**From:** Fiona Fitzgerald  
**Sent:** 06 June 2018 12:04  
**To:** Planning.Responses  
**Cc:** Anita Gardner  
**Subject:** FW: CM/6/18 PI land at Northwood Farm

Sorry for the delay in responding. Environmental Health does not have any objections in principle to this application. However, I have a few questions, and would like the following conditions to be placed on any permission given:

Figure C-1
Noise Measurement Locations

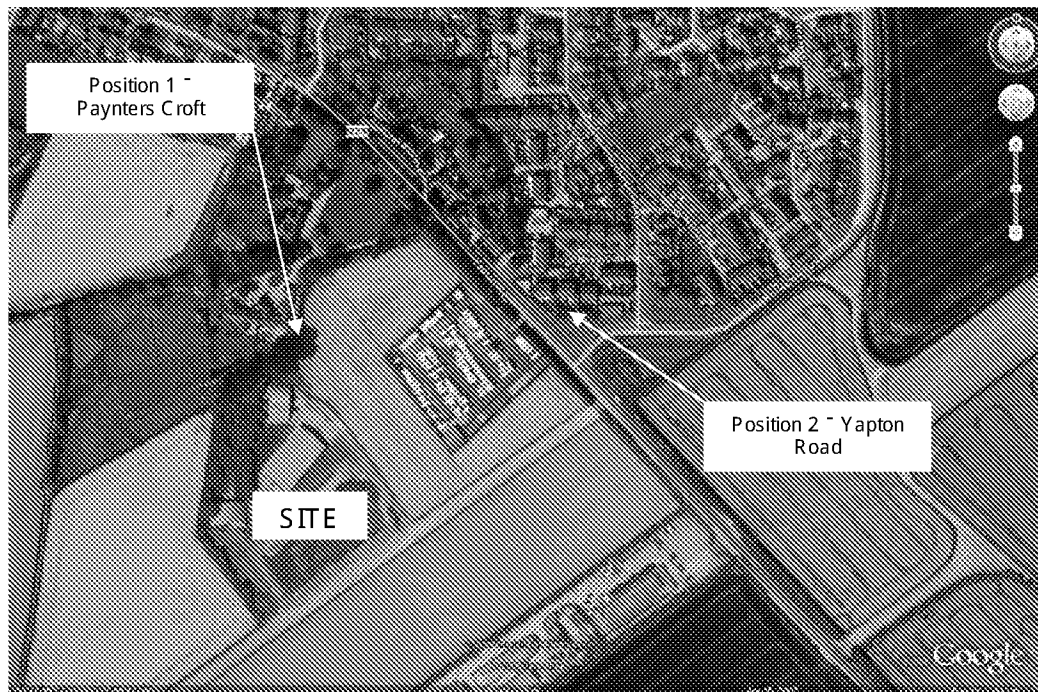
1. With regard to the Acoustic Report from Sharps Redmore dated 23<sup>rd</sup> February 2018 (Project No 1717351) it would appear that the applicant has missed the two closest residential properties to the site which are 1 Meadow Cottage and Paynters Croft (both on Burndell Road). Please could the calculations be re-done to take account of these residential properties?
